Recommended Comments for Approval - Concrush Increase to Capacity – SSD 8753

EPA Recommended Comments for Approval for SSD 8753

Assessment of Water Management in Response to Submissions – SSD 8753

Conceptual Stage 2 Water
Management Plan

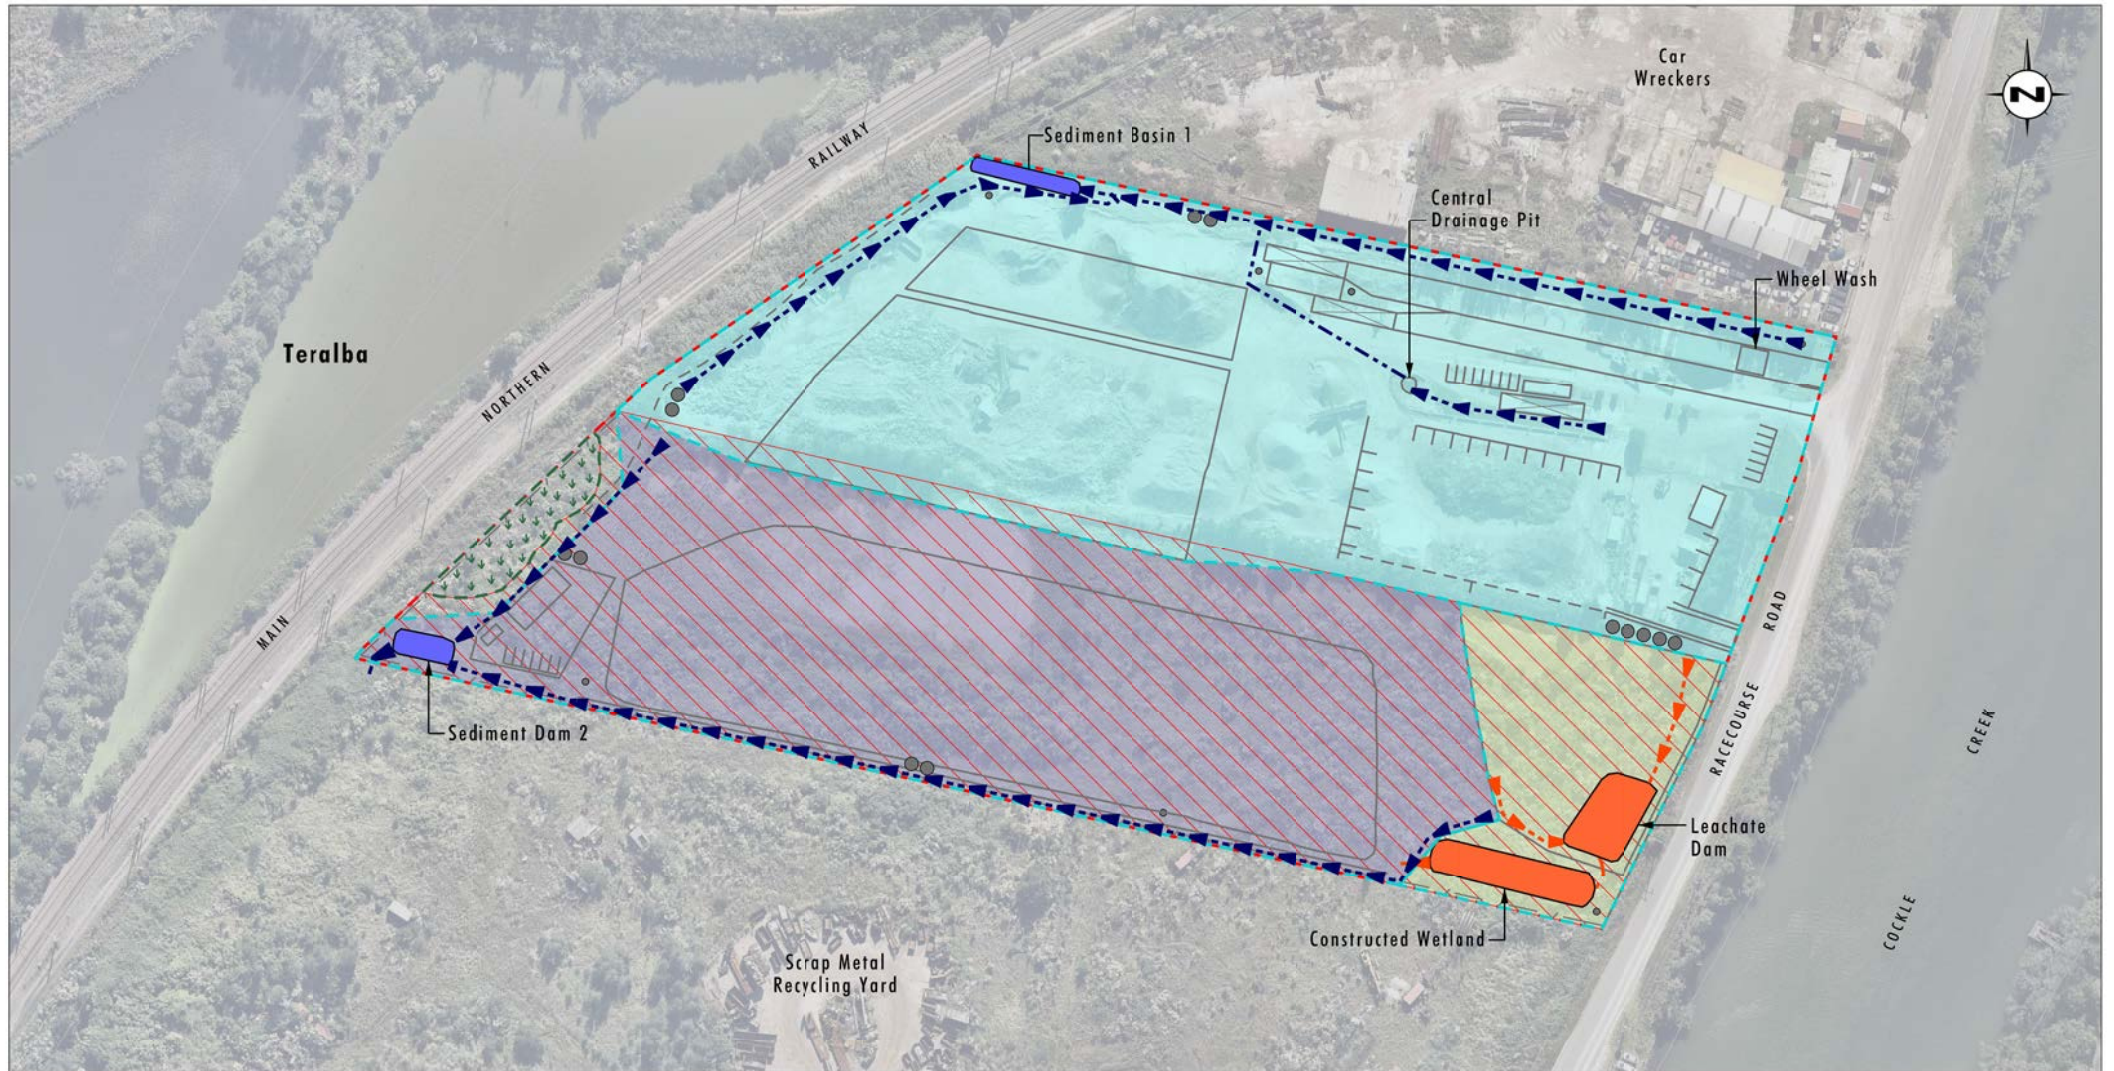
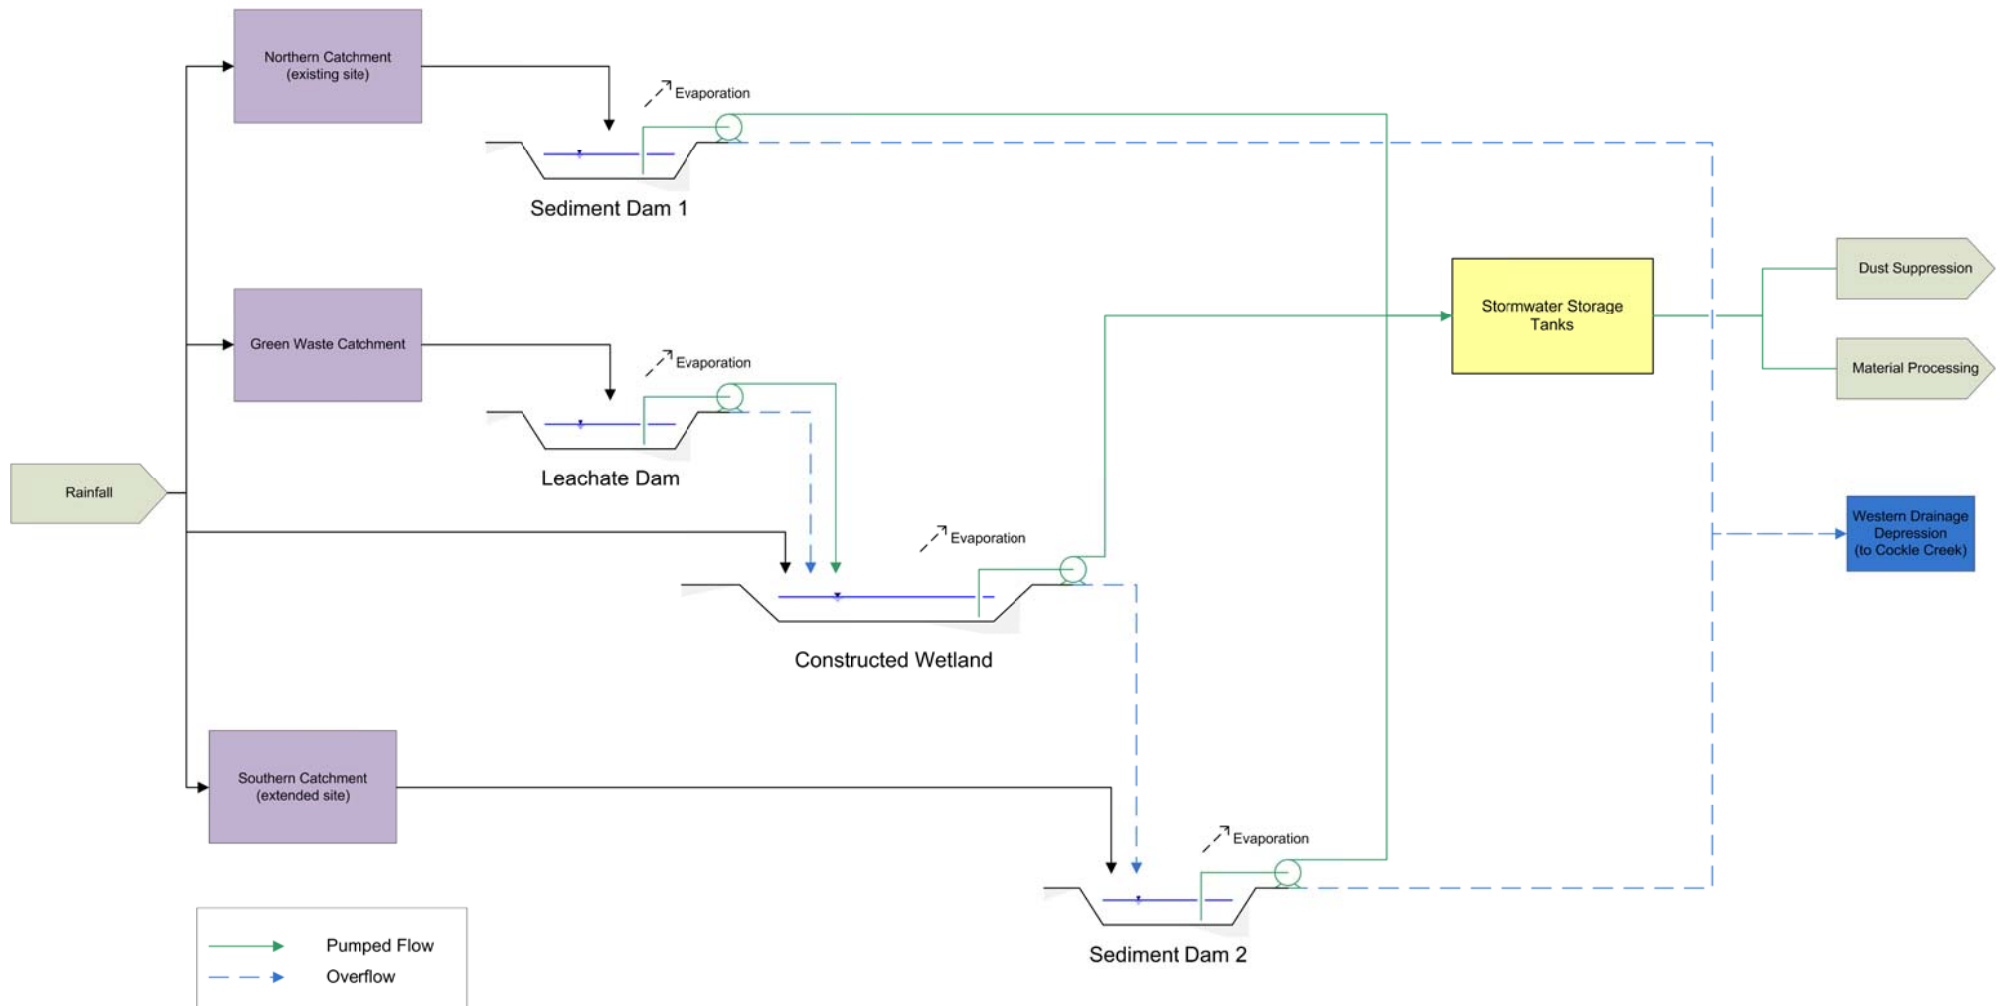
Sediment retention basins are designed to capture and treat stormwater containing 'uncontaminated' sediment. Monitoring from the existing site indicates runoff contains elevated metal concentrations. Chromium VI ranged up to 53µg/L, 53 times the guideline value, and copper ranged up to 76µg/L, 54 times the guideline value. The RtS indicates storage and processing of waste concrete is the source of these pollutants.

Further assessment is required to determine whether the proposed stormwater management system will adequately treat runoff or if alternative and/or additional measures are required to minimise and mitigate potential impacts (e.g. to reduce metal concentrations).

The EPA indicated that the type C sediment retention basins, proposed in the EIS, may not be appropriate or adequate to treat runoff that contains pollutants other than coarse sediment. The RtS now proposes type D sediment retention basins, sized to treat runoff from the 5-day 85th percentile rainfall event, citing the recommendations of the Blue Book (*Managing Urban Stormwater: Soils and Construction, Volume 1* [Landcom, 2004]). Landcom (2004) provides guidance on stormwater management during the construction-phase of urban development, which may not be appropriate for longer-term operation-phase stormwater management.

Managing Urban Stormwater: Soils and Construction, Volume 2b Waste Landfills (DECC, 2008) provides relevant guidance for ongoing stormwater management at the proposed waste management facility. DECC (2008) recommends that where the duration of disturbance is more than three years and the receiving environment is not sensitive, Type D sediment retention basins should be designed to achieve the required water quality for storms up to the 90th percentile 5-day storm event (i.e. 51.8mm at Newcastle).

The proposed basins appear undersized for ongoing management of sediment laden stormwater.

It is unclear whether the sediment retention basins would be lined. The basins would receive leachate overflows and contaminated runoff from waste processing and stockpiling areas. The RtS indicates the wastewater will contain a range of pollutants, including nutrients and metals.

Wastewater storages, such as the proposed basins, should therefore be lined consistent with the design specifications for leachate dams recommended in the *Environmental Guidelines Solid Waste Landfills* (EPA, 2016).

The sediment retention basins would be dewatered to the stormwater reuse system and no controlled discharges to waterways are proposed. This partially mitigates the water pollution risks, however, managed overflows would occur as a result of rainfall in excess of the design capacity of the basins and these are likely to carry a range of pollutants.

The RtS does not adequately assess the potential impact of these discharges. Table 4.5 of the RtS estimates concentrations of nitrogen compounds and total phosphorus from SD2. These do not include all pollutants expected to be present at non-trivial levels (e.g. metals) and discharges from SD1 are not characterised. The RtS does not assess whether the discharges will maintain or restore

the environmental values of the receiving waterway. A discharge impact assessment is required to ensure residual water pollution risks are appropriately managed.
